State of Washington
DEPARTMENT OF FISH AND WILDLIFE

June 12, 2024

SUBJECT: RE: CU-24-00003 Schnebly Coulee Solar Farm - Notice of Application

Figure 5.1. Project Area layout and proposed fencing at the Schneibly Coulee Solar Energy Project, Kittitas County, Washington.

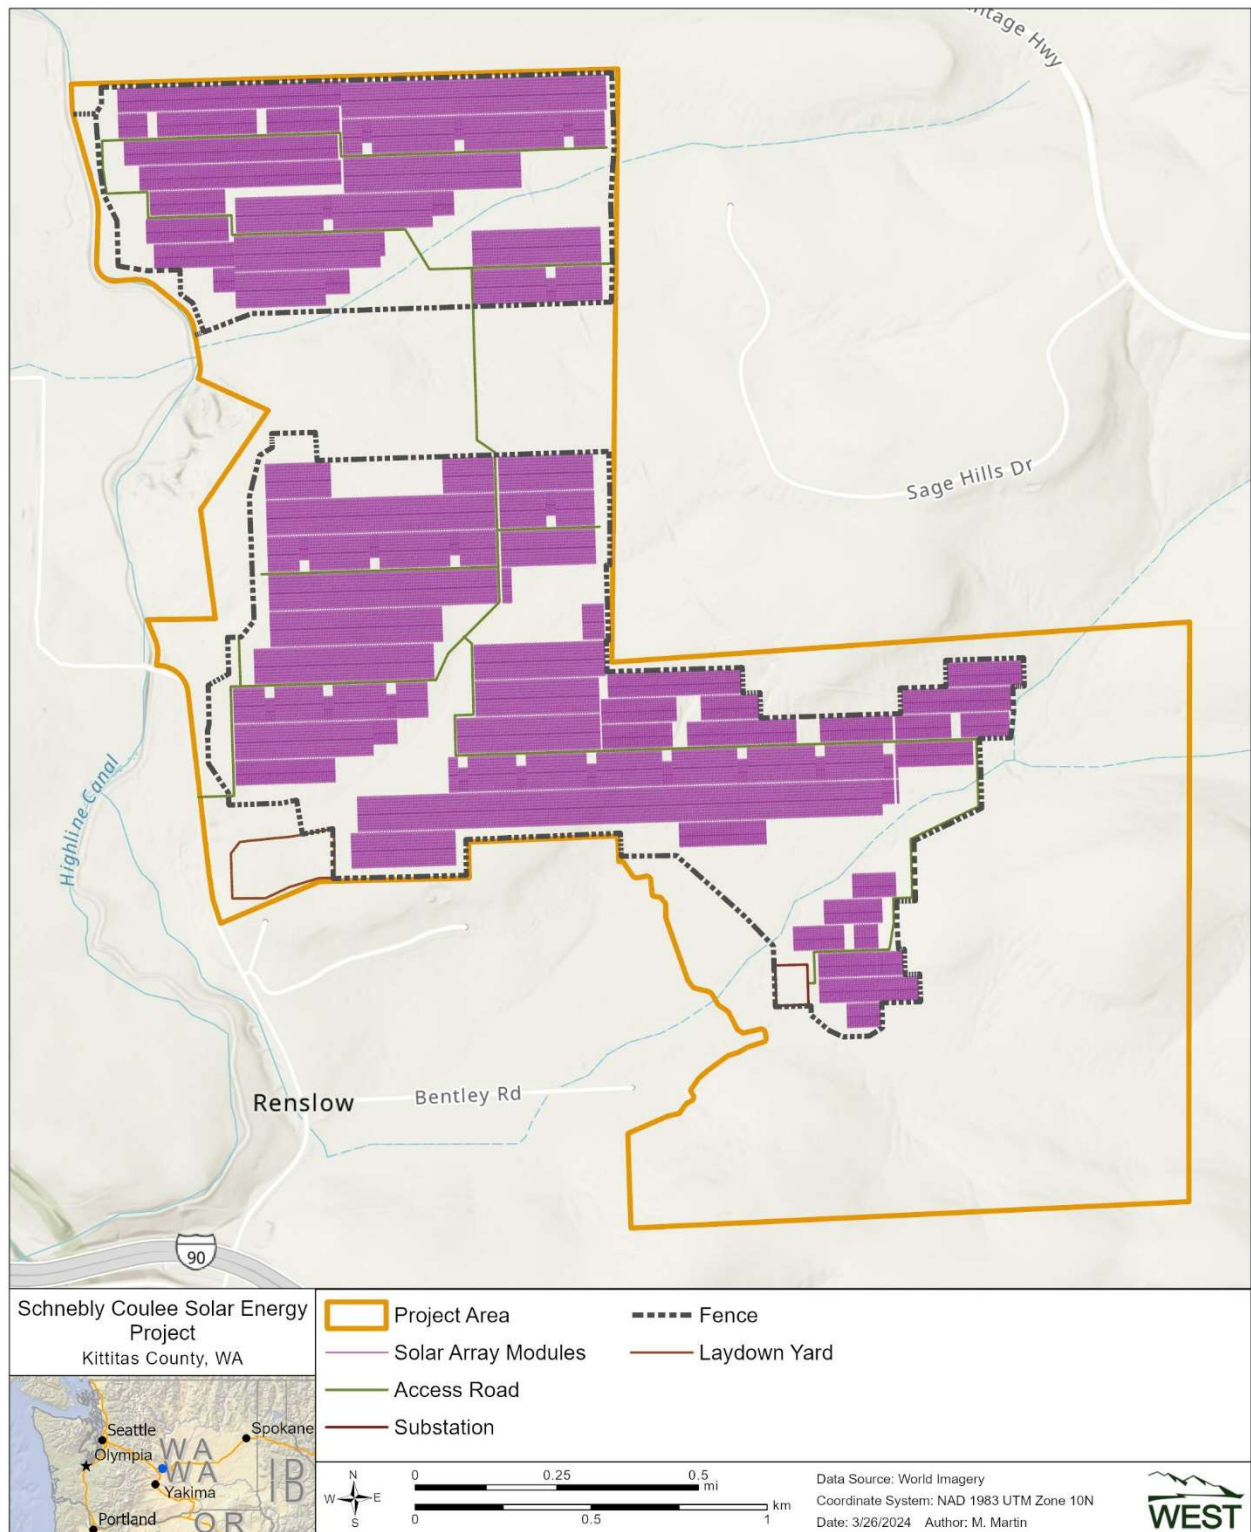
- Incorporation of wildlife friendly elk exclusion specifications into the solar perimeter fence with modifications to allow small wildlife movement within the project

Figure 7.1. Conservation easements adjacent to, and within, the Project Area at the Schneibly Coulee Solar Energy Project, Kittitas County, Washington.

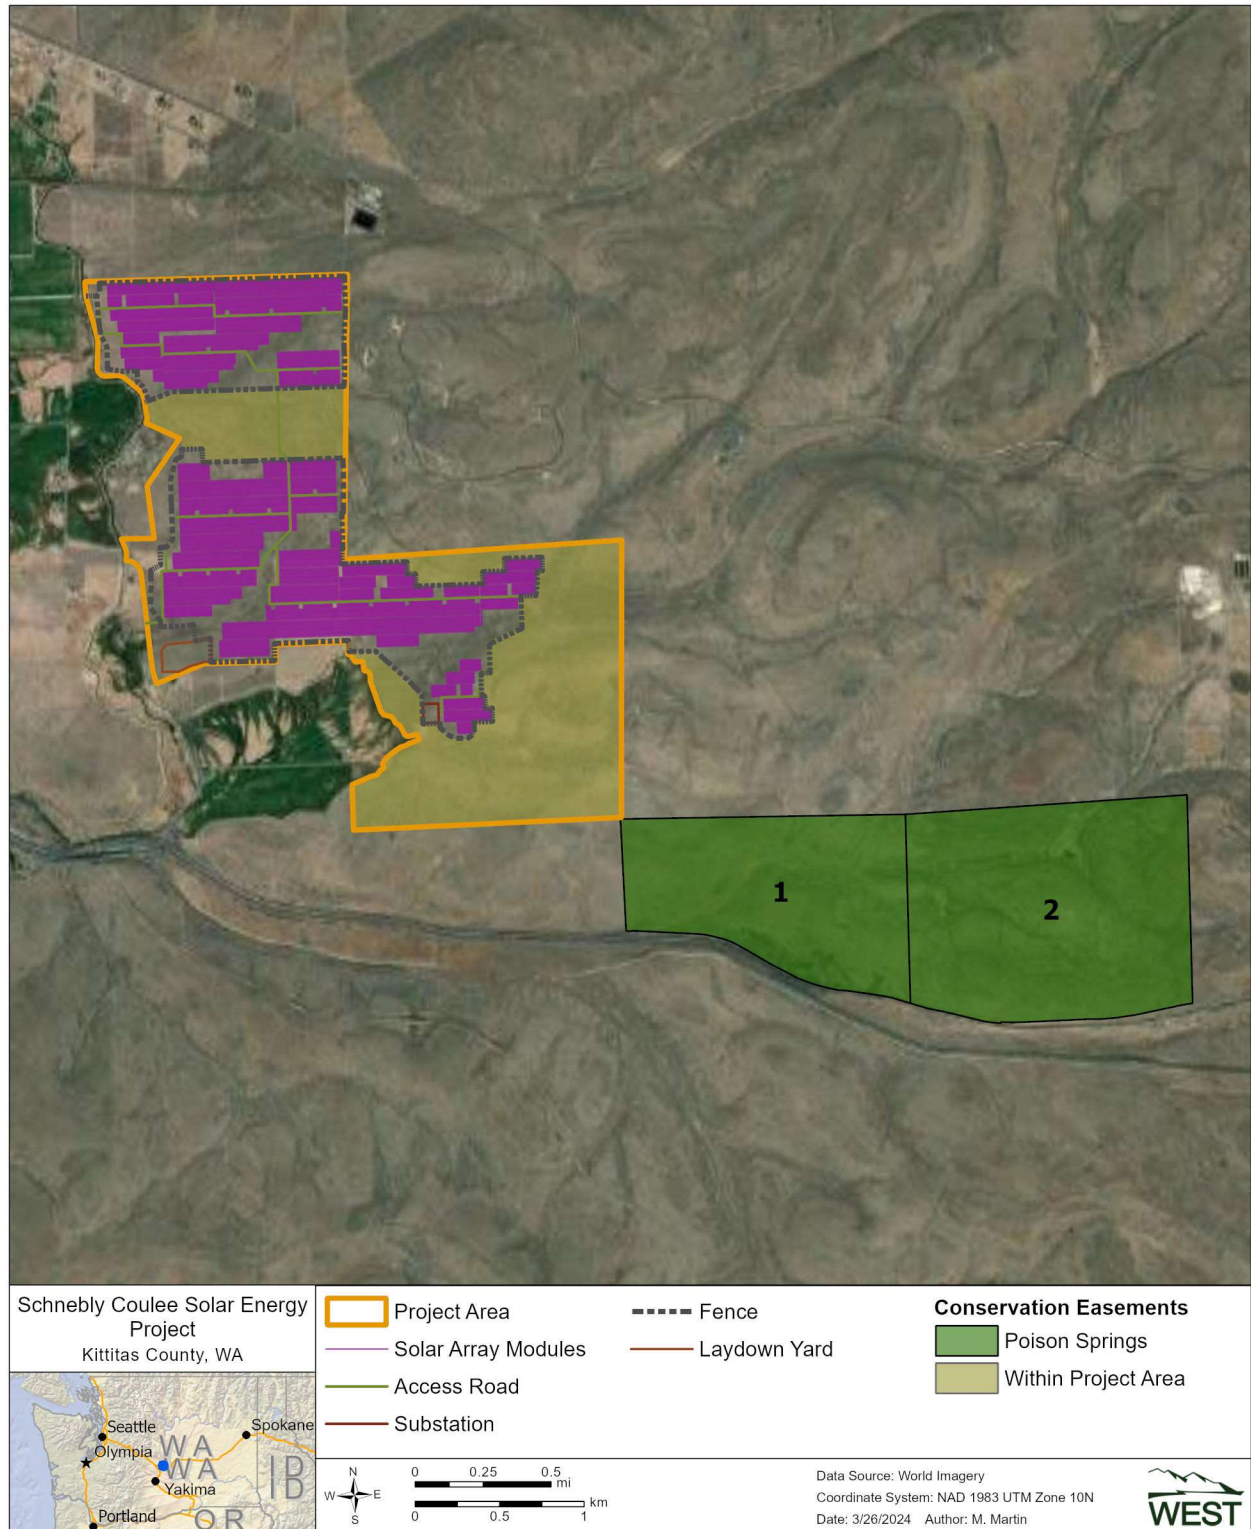
The applicant's current Habitat Management Plan provides details about mitigation but excludes important information regarding conservation easement management and transmission line impacts. However, there has been ongoing discussion between WDFW and the applicant to develop appropriate management strategies for the planned conservation easement, address transmission line impacts, and to incorporate these factors into a Mitigation Plan and updated Habitat Management Plan. We have a few comments regarding the submitted application materials below.

- The applicant works with WDFW to create terms for the conservation easement which could include, but not be limited to; protection of land for the life of the project, grazing at or below current levels, and no loss of habitat value by grazing, recreation, or other factors within control of the applicant.
